**Project:** Casco Bay PG – Stair/Elevator Tower Restoration  
**Project #:** WO 3604  
**Date/Time:** June 30, 2016, 9:00 a.m.  
**Observers** Joshua Martin-McNaughton, Author (BSE)

12 EXHAUST VENT TRIM DETAIL  
3"=1'-0"

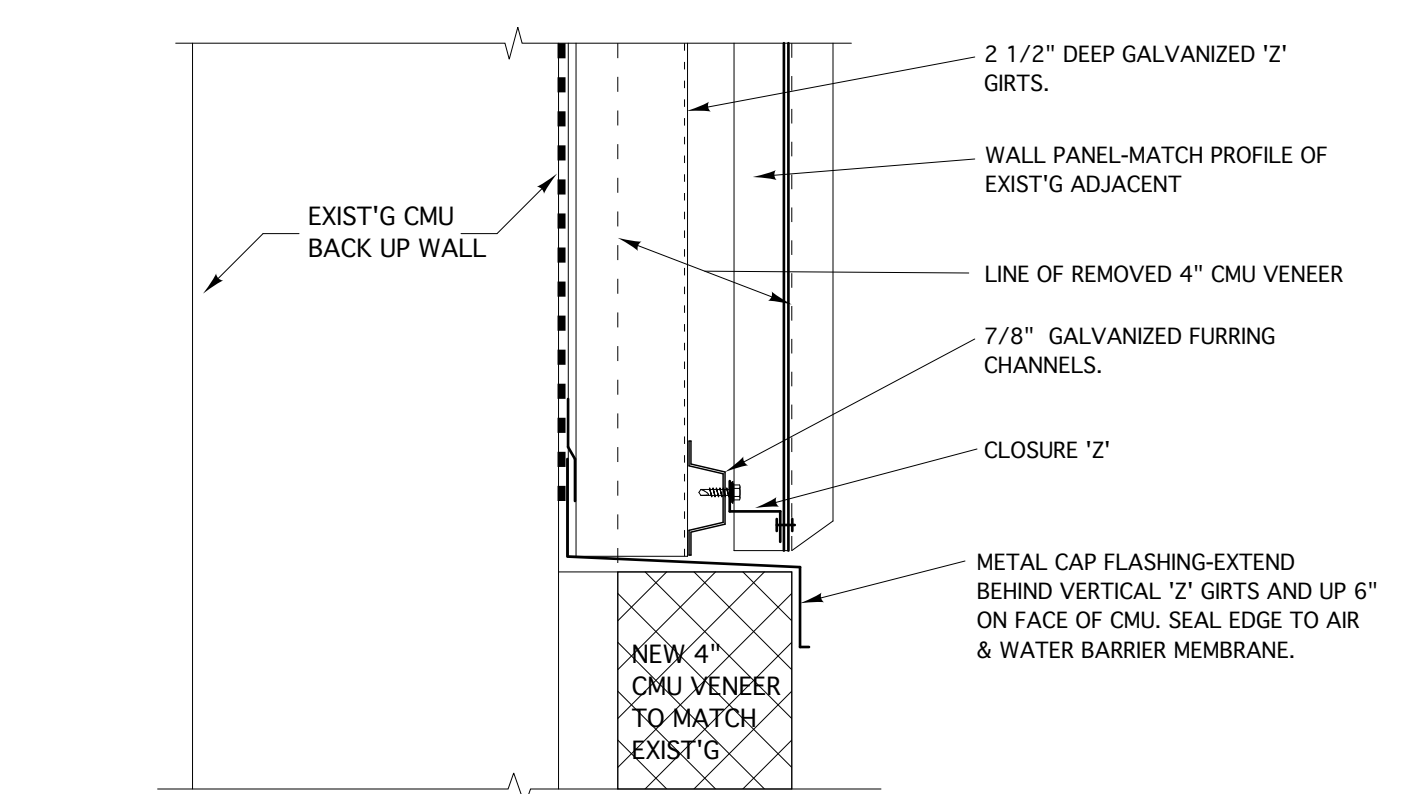
1. Items 2, 3 & 4 below address the exterior punch list items for levels 4 and 5.
2. The windows, elevator curtain wall and wall panels need to be washed down of dust and debris prior to removal of the staging.
3. At the elevator louver, there is exposed wood blocking coated in air/vapor barrier, see adjacent photo. The exposed wood needs to be covered in metal flashing and the louver perimeter sealed.
4. At a few locations staging and equipment have bumped into the wall panel and scraped small areas of paint off. These areas are to be touched up with paint to match the wall panel.
5. The metal wall panel installers are working at level 3 and the levels below, see adjacent photo. Staging is anticipated to start to be removed once the above items are completed.
